# COUNTY COUNCIL'S RESPONSE TO CONSULTATION ON THE FOLLOWING DEVELOPMENT PROPOSAL

**Application No:** 20/02083/OUT

**Proposal:** Outline - Erection of 14 two-storey dwellings

**Location:** Land North of Hempton Road and west of Wimbourn Close, Deddington

Land off Hempton Road, Deddington - ILLUSTRATIVE LAYOUT

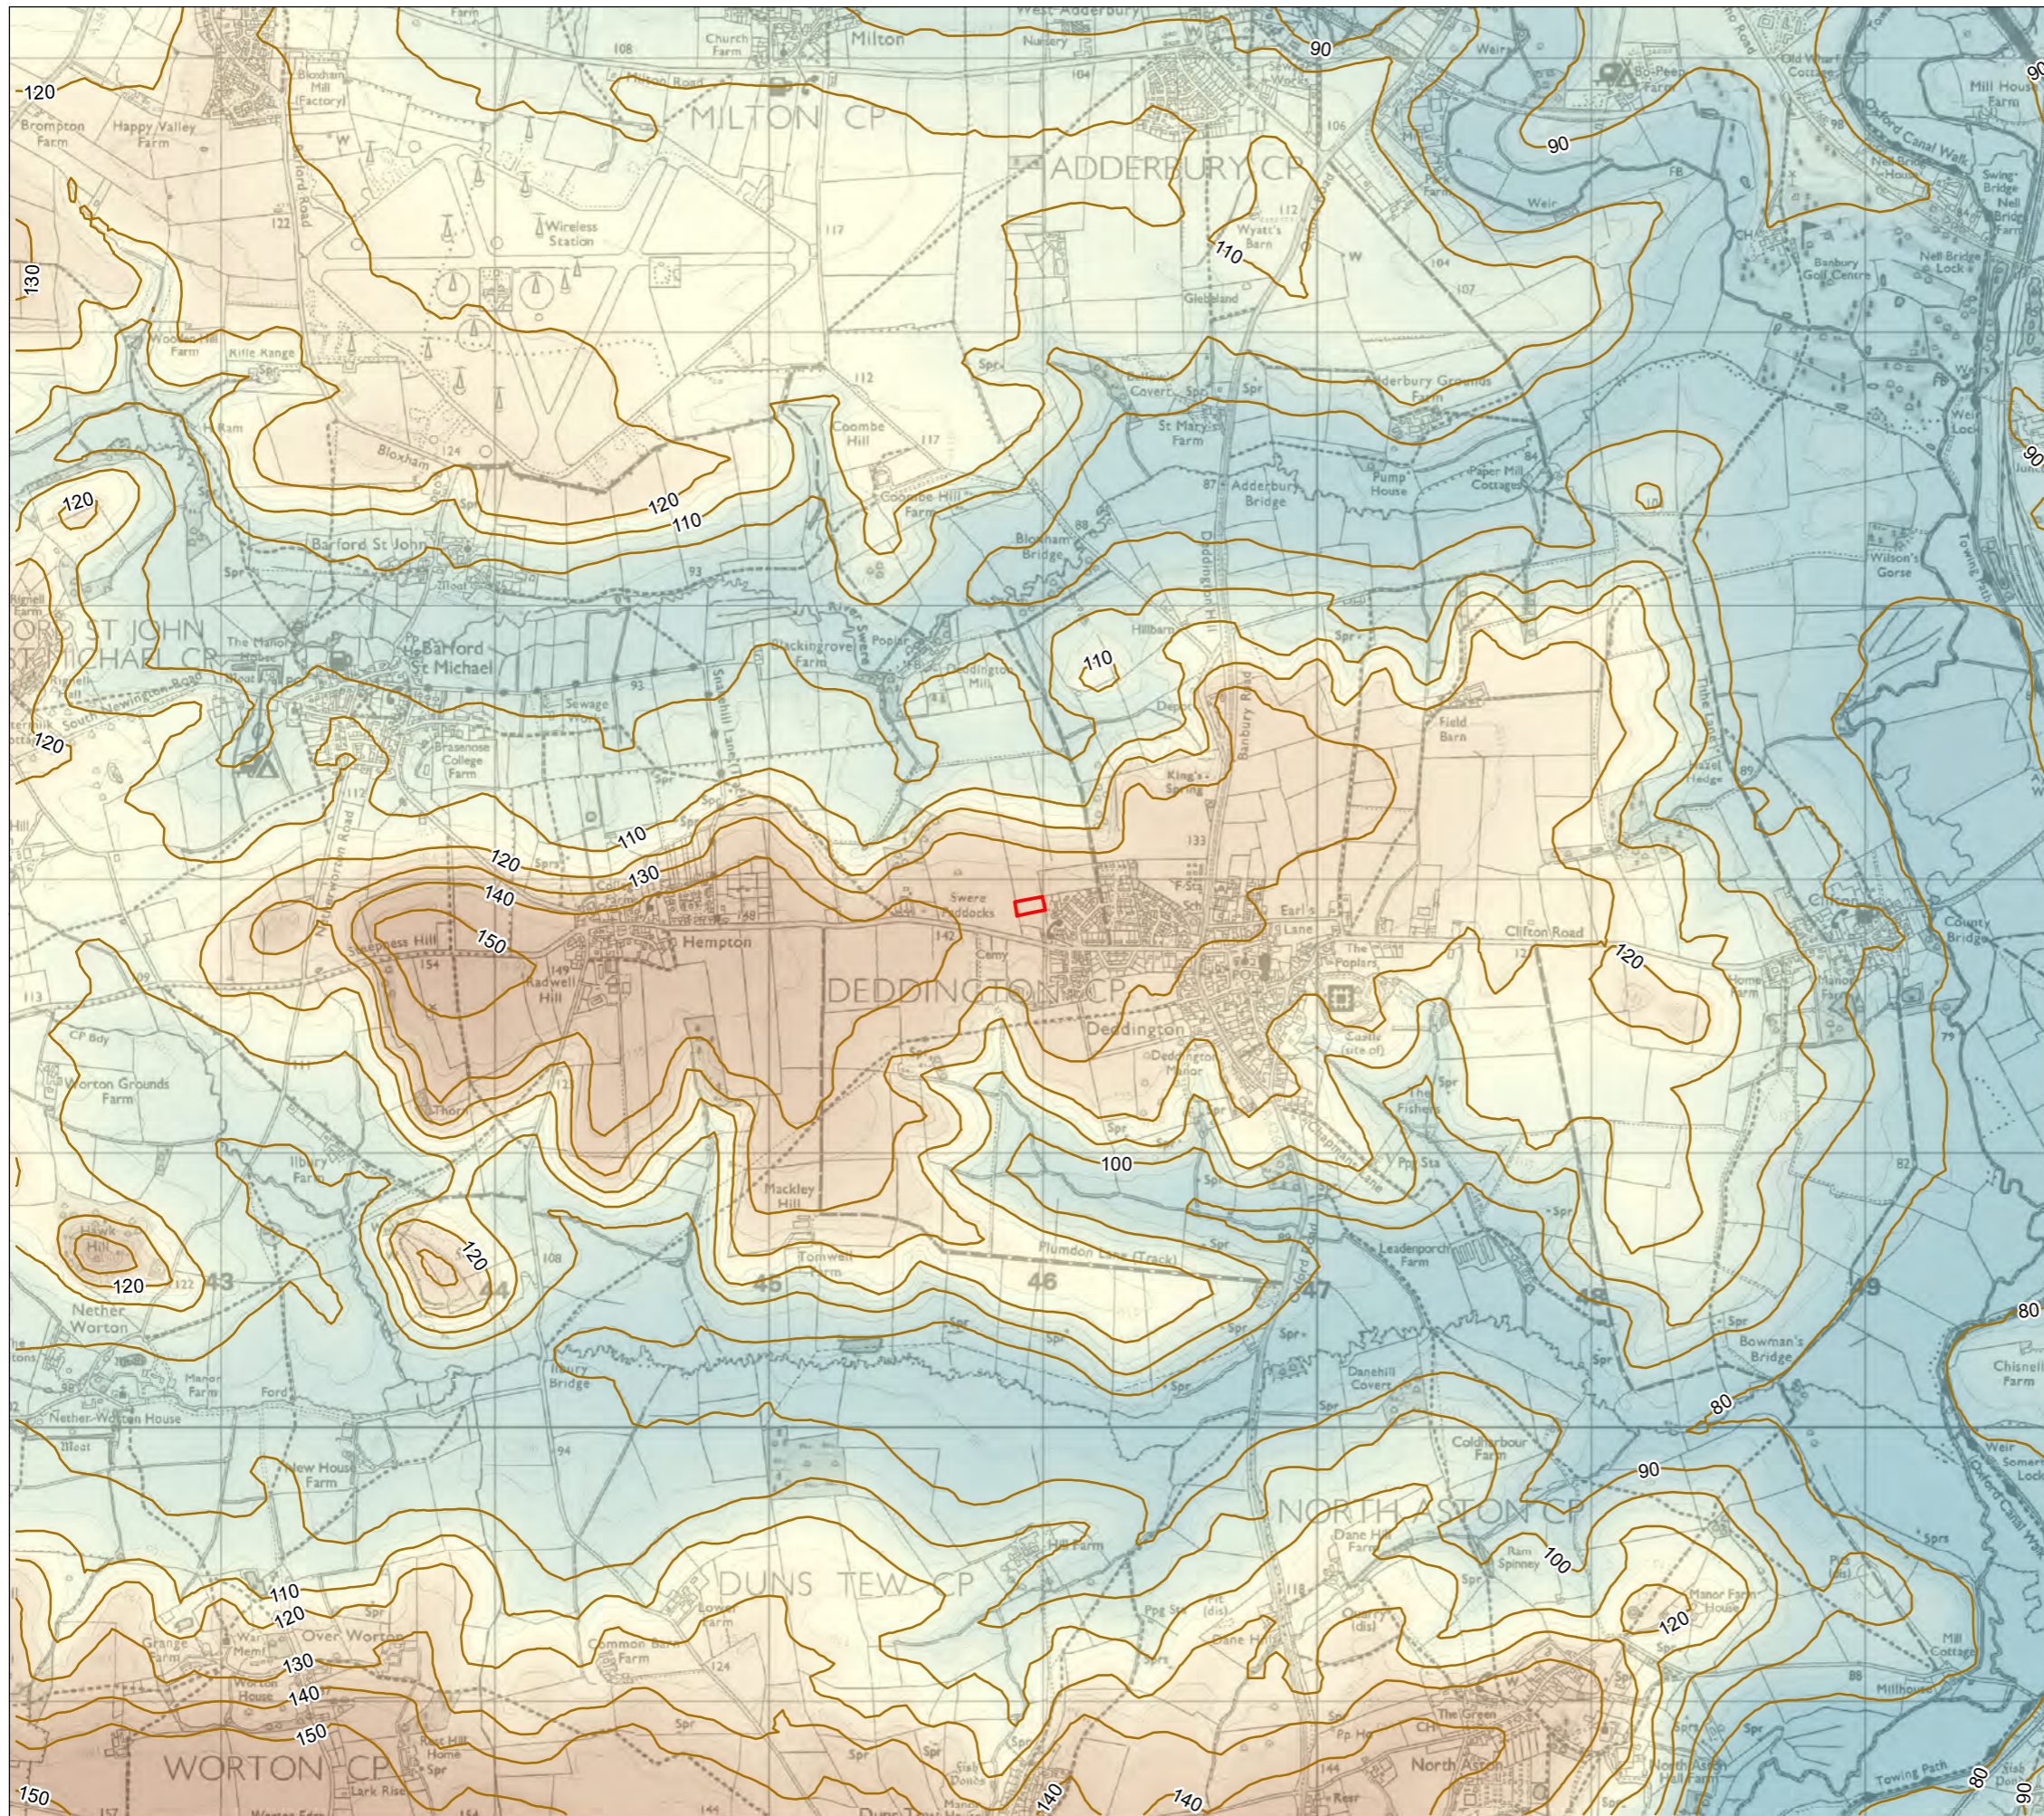
It is noted that the layout of the Phase 1 site is very different from that given outline permission, partly because the access road did not extend up to the northern boundary, as is currently indicated on the Illustrative Layout and Masterplan. The access road through Phase 1 is the connection to the public highway and therefore it

must be included in the red line area – this is a technicality but also a reason for objection.

Considering the above points, I have concerns about the off-road parking for Plot 6 that emerges between the two visitor parking bays and so the visibility will be restricted. Also, there are a number of trees (in both Phases) shown very close to the carriageway. With the total of 31 dwellings I expect the preference will be to have the spine road adopted, in which case the requirements should be taken into consideration at the reserved matters stage.

The application form does not give the number of bedrooms in each dwelling but this information is provided on the Illustrative Layout. Using the standards in the OCC Residential Roads Design Guide (2003) – Second Edition (2015), a total of 5.7 unallocated (visitor) spaces are required. Thus, a minimum of five visitor spaces is required to make the provision acceptable. This corresponds to the seven visitor spaces that are to be incorporated into the approved Phase 1 development for 21 dwellings. The significant lack of visitor parking is a reason for objection.

Garages are to have minimum internal dimensions of 6.0m x 3.0m to be counted as a parking space. This is particularly relevant for Plots 12 and 13 as they have only one allocated off-road space. Properties without a garage are expected to have a shed or other secure facility for cycle storage.

The Illustrative Layout shows a pedestrian link to Wimborn Close, which would route across third-party land to the east of the site before connecting to the public highway. There are two points where the highway boundary on Wimborn Close meets the Phase 1 eastern boundary, so these locations would be more suitable for the pedestrian link. The applicant is recommended to make contact with OCC Highway Records to ascertain the exact highway boundary ( <https://www2.oxfordshire.gov.uk/cms/content/contact-highway-records> ).

Infiltration Basin Details:
 Design based on Impermeable Area of 0.676ha (as measured from architects layout with an additional 10% allowance for urban creep)

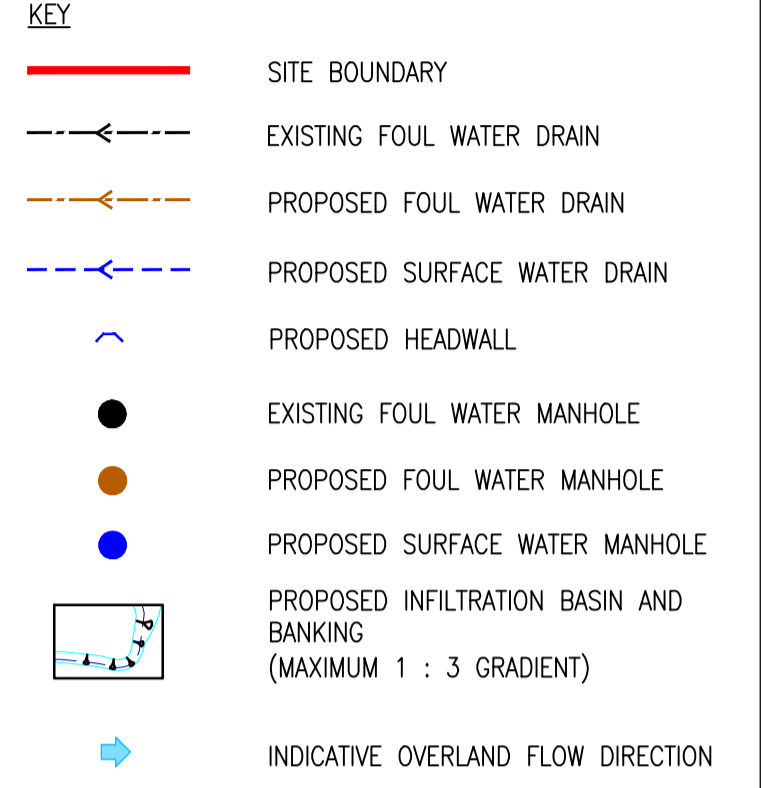
Proposal will alter natural drainage regime to the extent it will pose a flood risk due to increased surface water run-off rates.

Applicant must provide calculation files clearly indicating how a gravity system is to be delivered with greenfield discharge rates.

The LLFA feel the below figures are above green-field run-off rates for the site

1:1 flow rate 63l/s

1:30 flow rate 146l/s

1:100 flow rate 230l/s
